WOODMOOR

Water & Sanitation District No. 1

November 22, 2017

RE: The Beach at Woodmoor PUD/Preliminary Plan (PUDSP-17-003) and The Beach at Woodmoor Final Plat (SF-17-015) - REVIEW 2

The Beach at Woodmoor Filing No. 1
 Captiva Beach Lane -- Plan and Profile
 Sanitary Sewer -- Plan and Profile
 El Paso County, Colorado

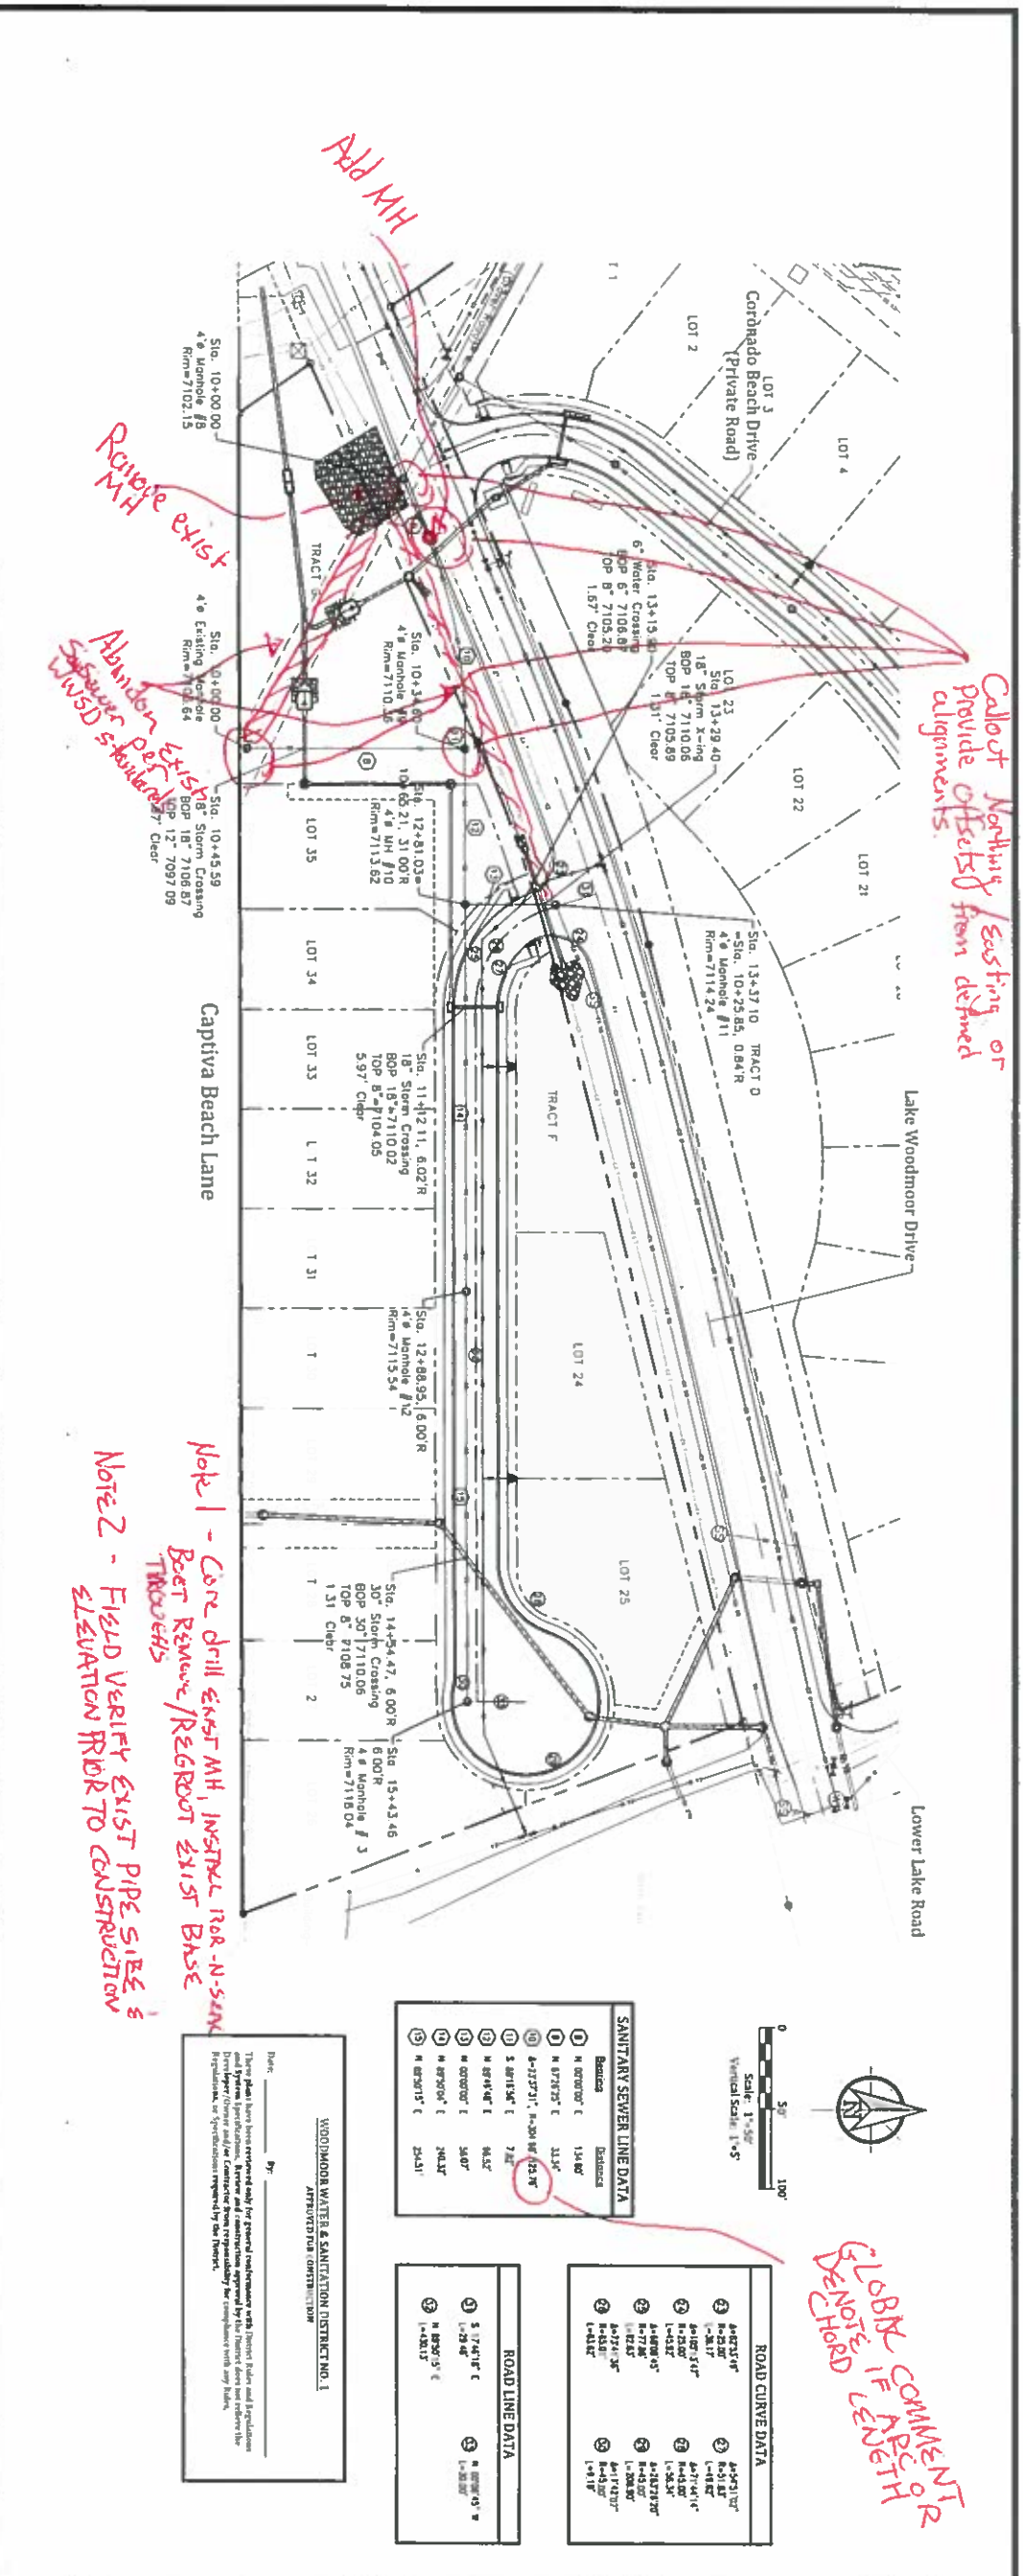
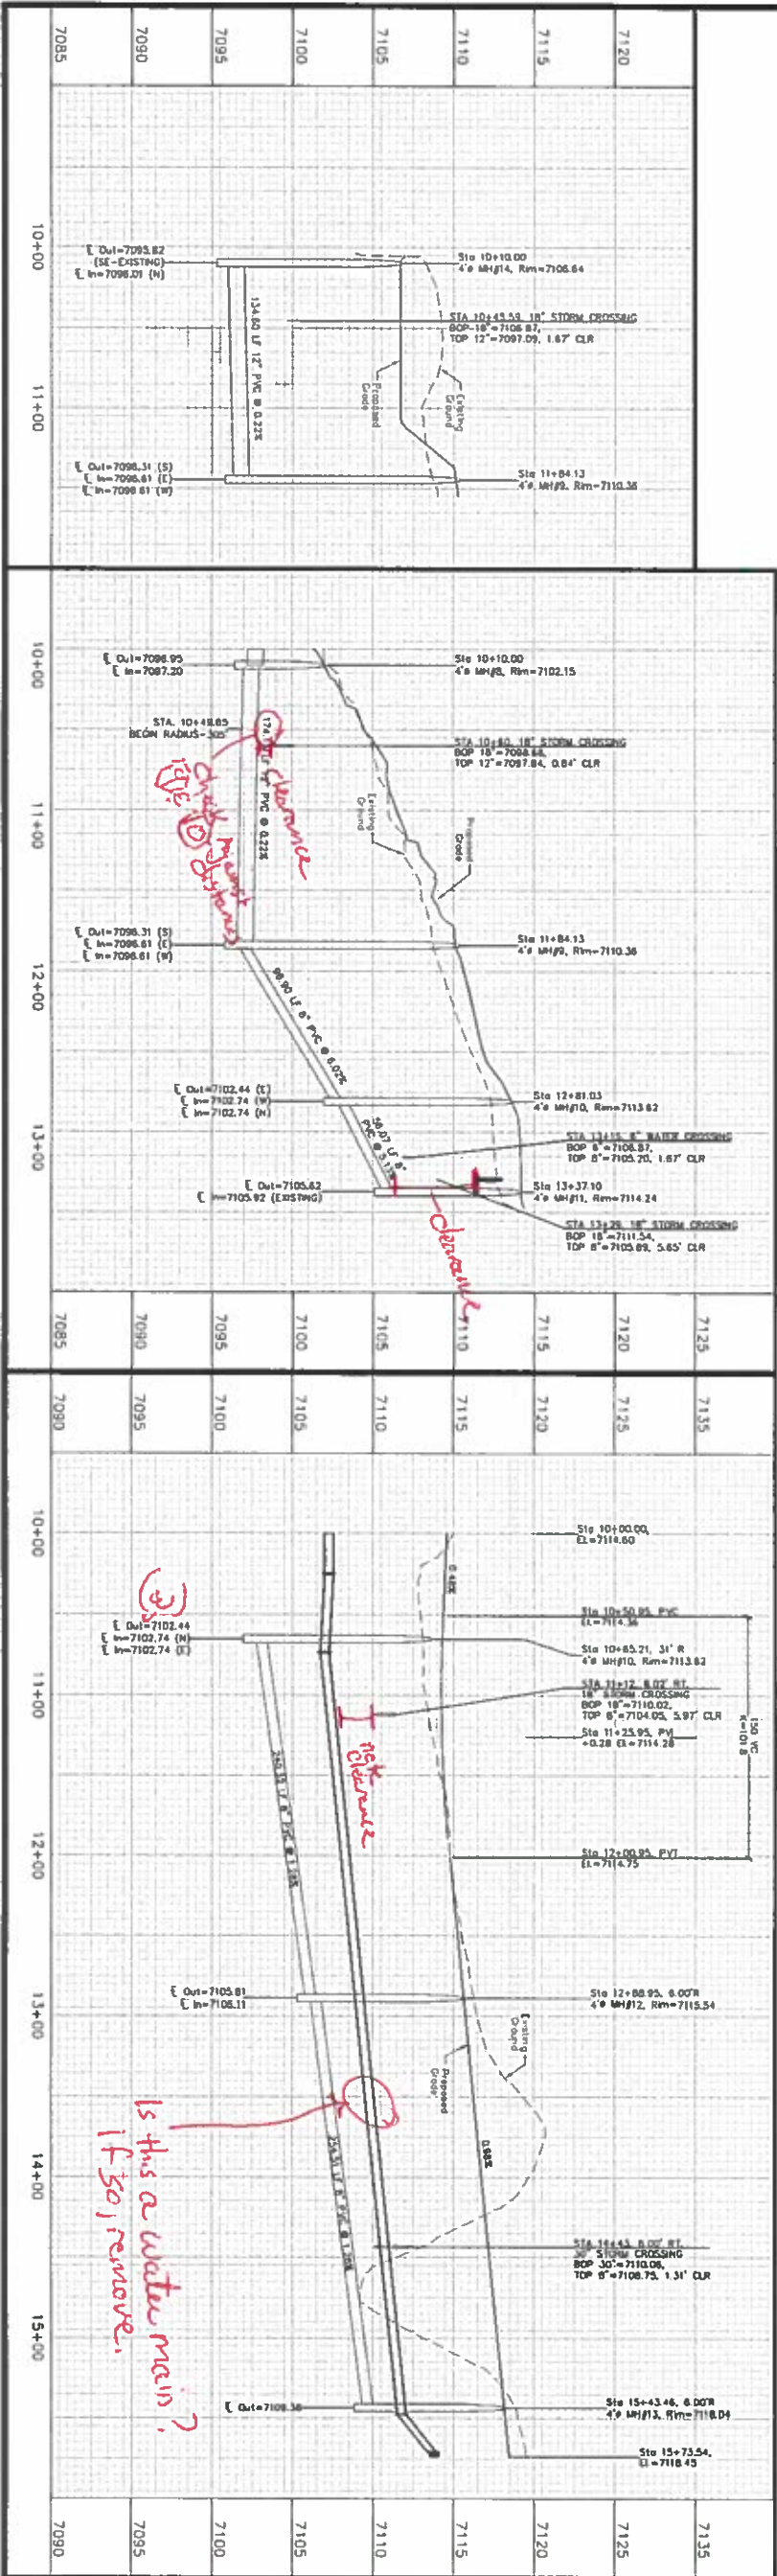
1. Per WWSD System Specifications 3.2.5.5, “The elevation drop through the trough of a manhole shall be 0.30 feet.” Elevation drops through manholes vary; revise to conform to System Specifications.
2. Per WWSD System Specifications 4.8.1, plans must show more details (ex. MH cut depth, etc.). Review District Plan and Profile requirements (Chapter 4) and revise The Beach package for compliance.
